**KIRKLEES METROPOLITAN COUNCIL
INVESTMENT & REGENERATION SERVICE**

DELEGATED DECISION TO DETERMINE PLANNING APPLICATIONS

Reference No: 2021/62/93489/W
Site Address: 37, Yew Street, Fartown, Huddersfield, HD2 2RN
Description: Erection of single storey rear extension
Recommending Officer: Lucy Taylor

Officer Report.

Drawing
Proposed Floor Plans and Elevations

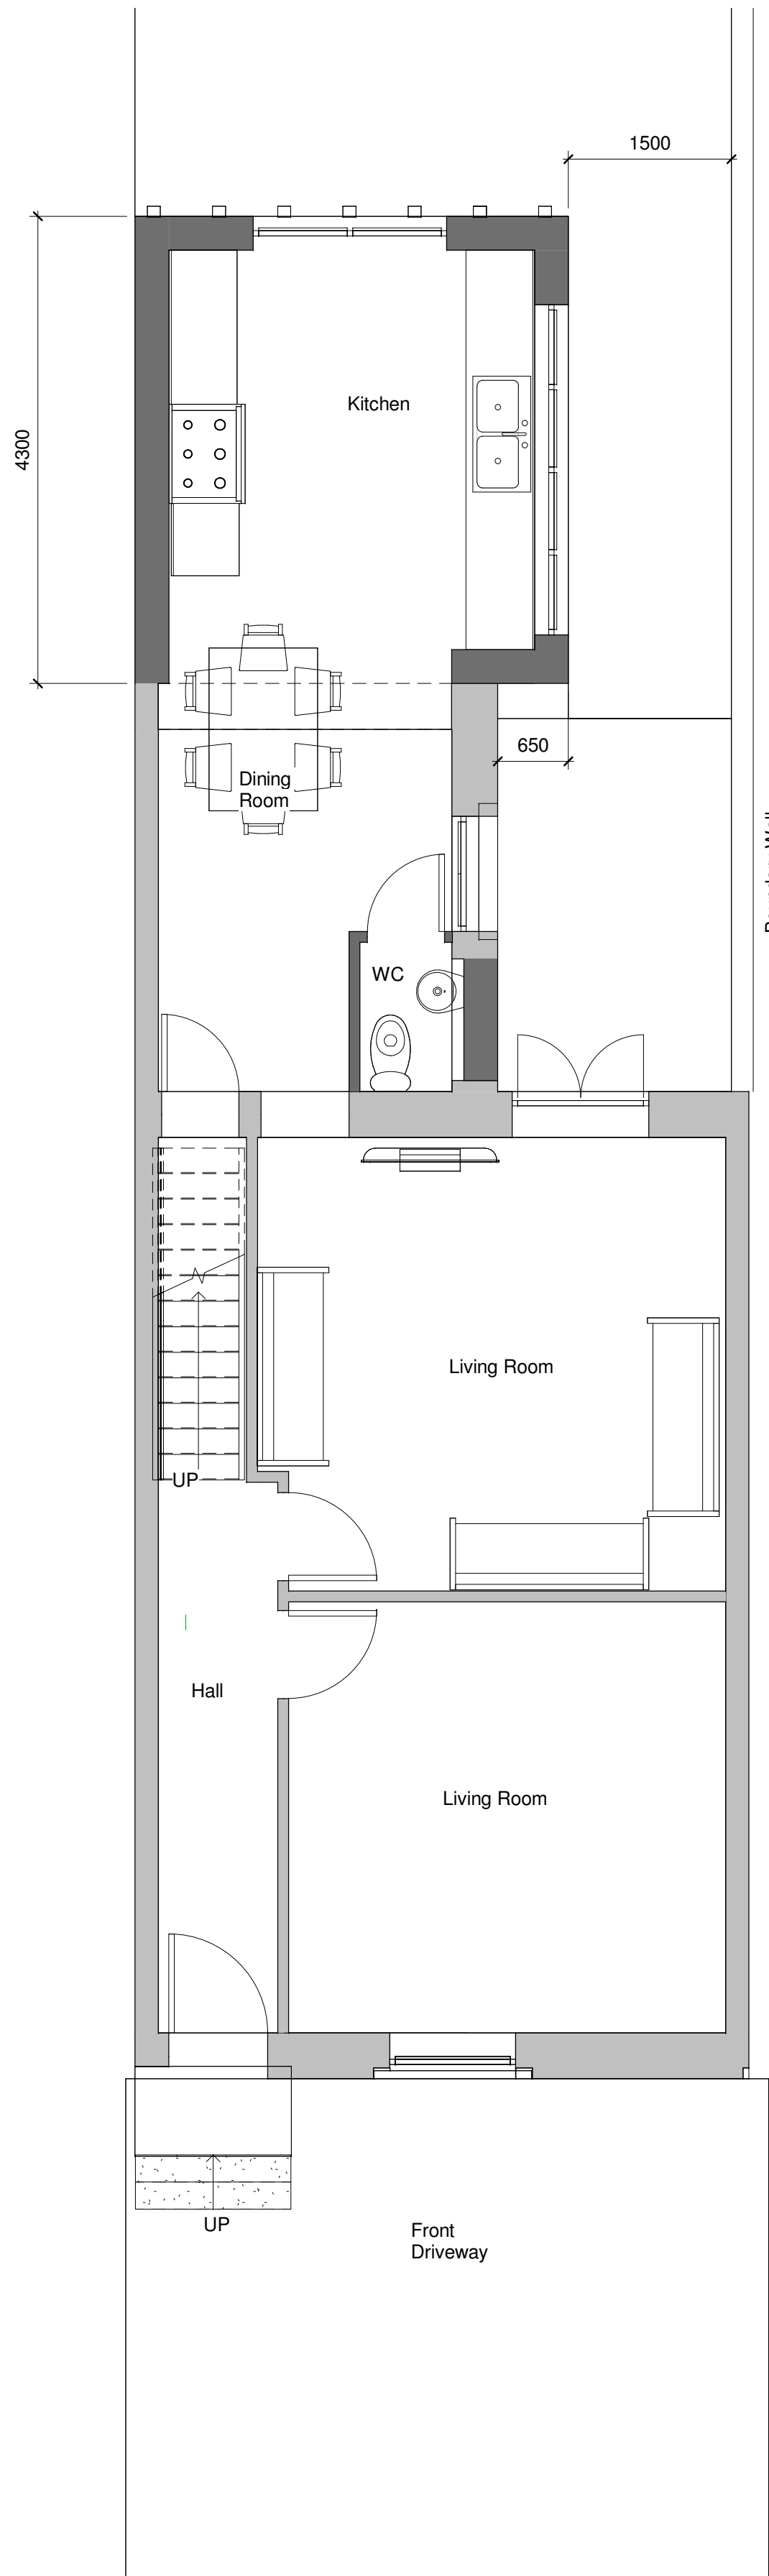
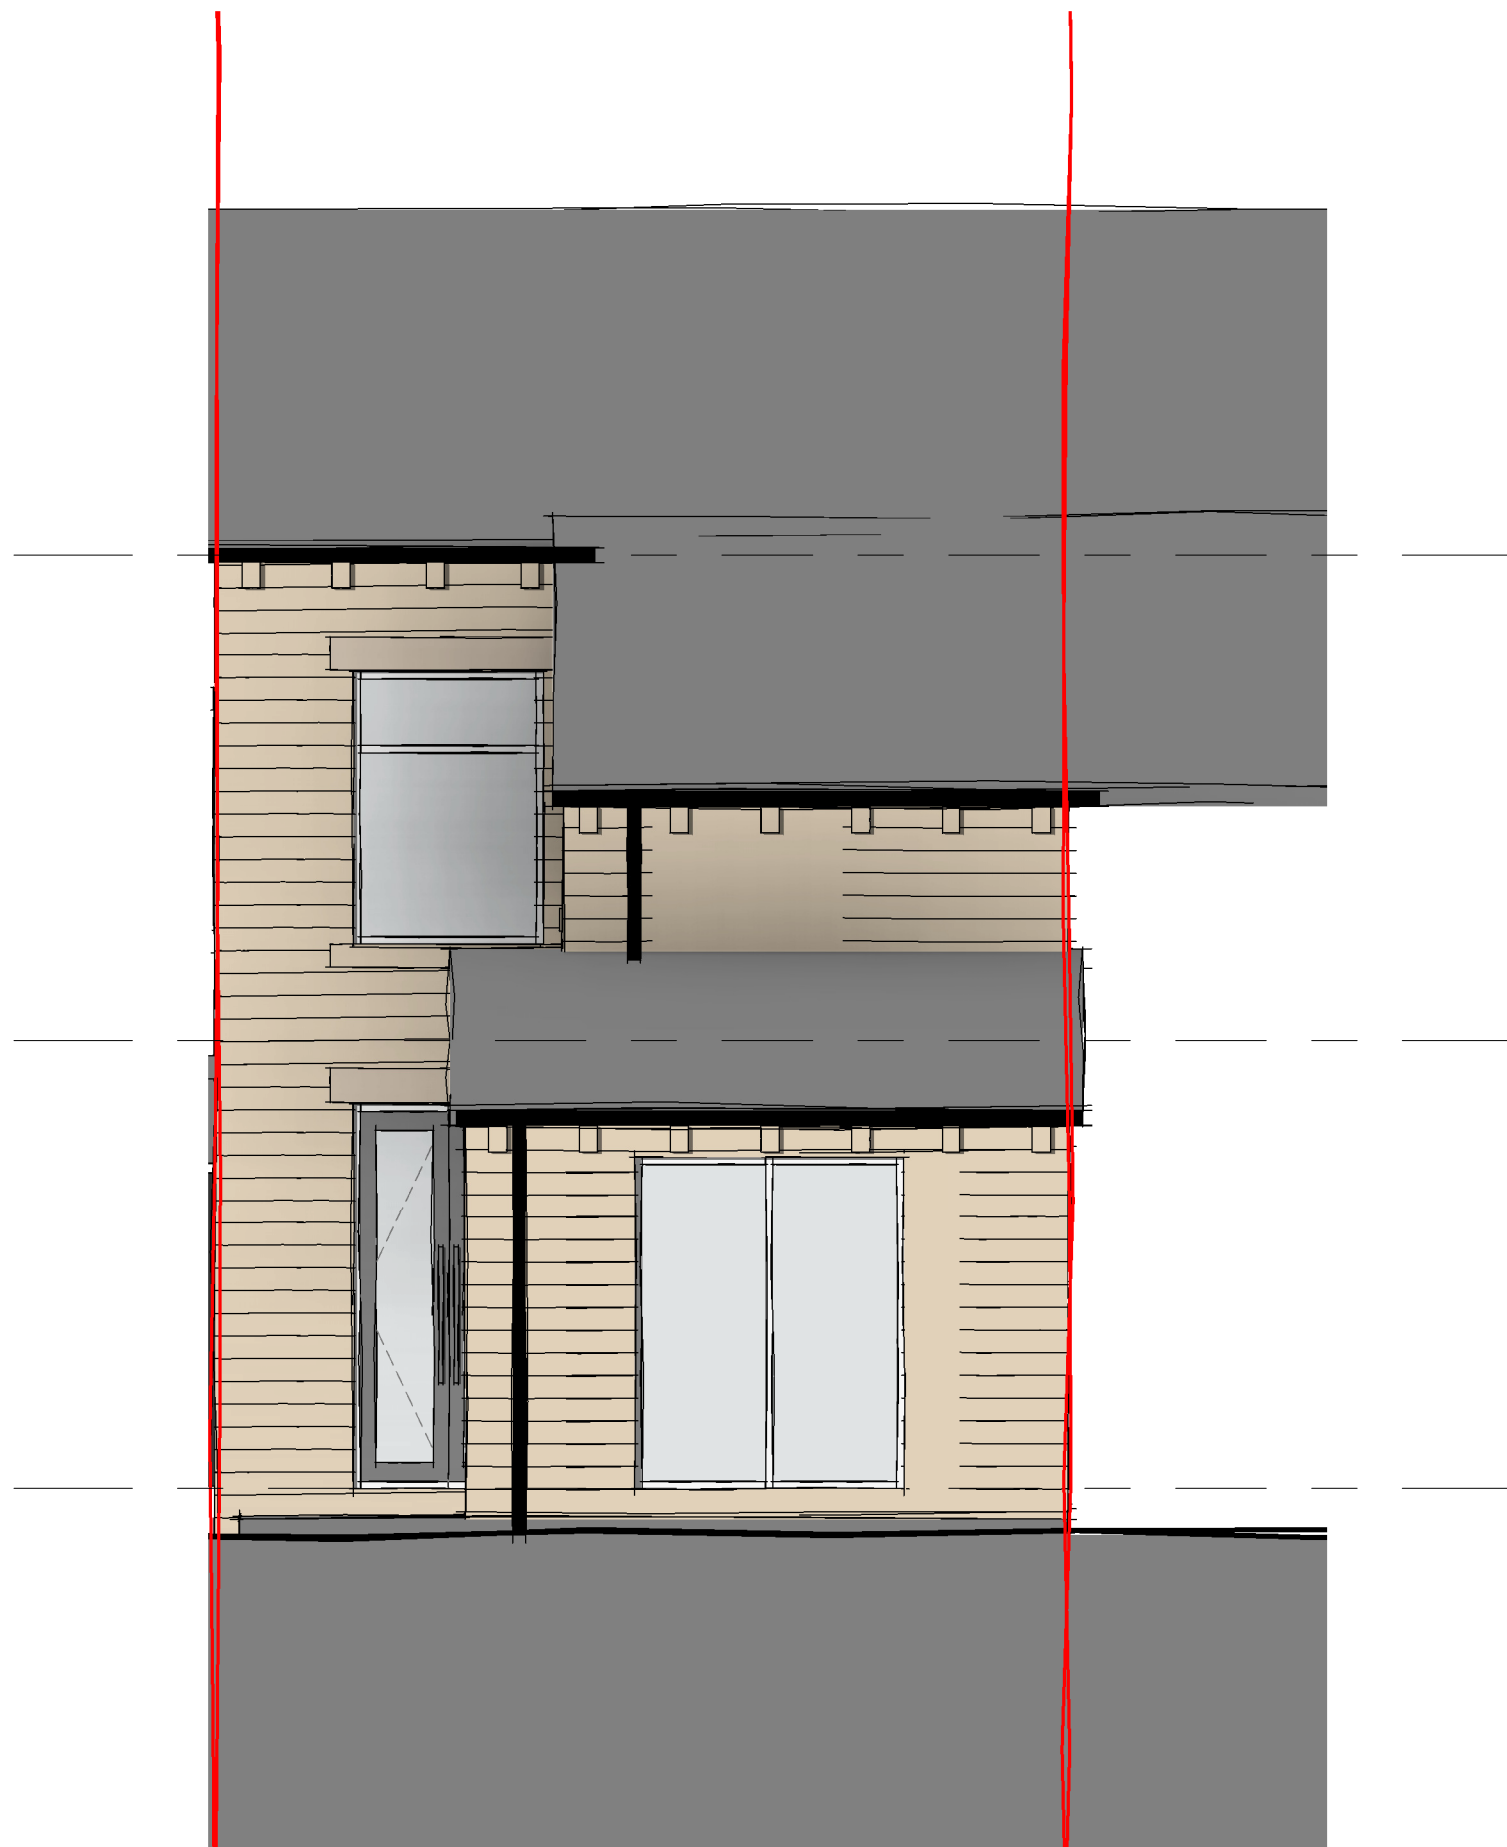
The case officer sought amended plans to reduce the proposed width of the rear extension for reasons of visual amenity and to increase the design value of the proposed scheme. In response, the applicant submitted amended plans that reduced the proposed width of the extension from 4.5 metres to 4 metres.
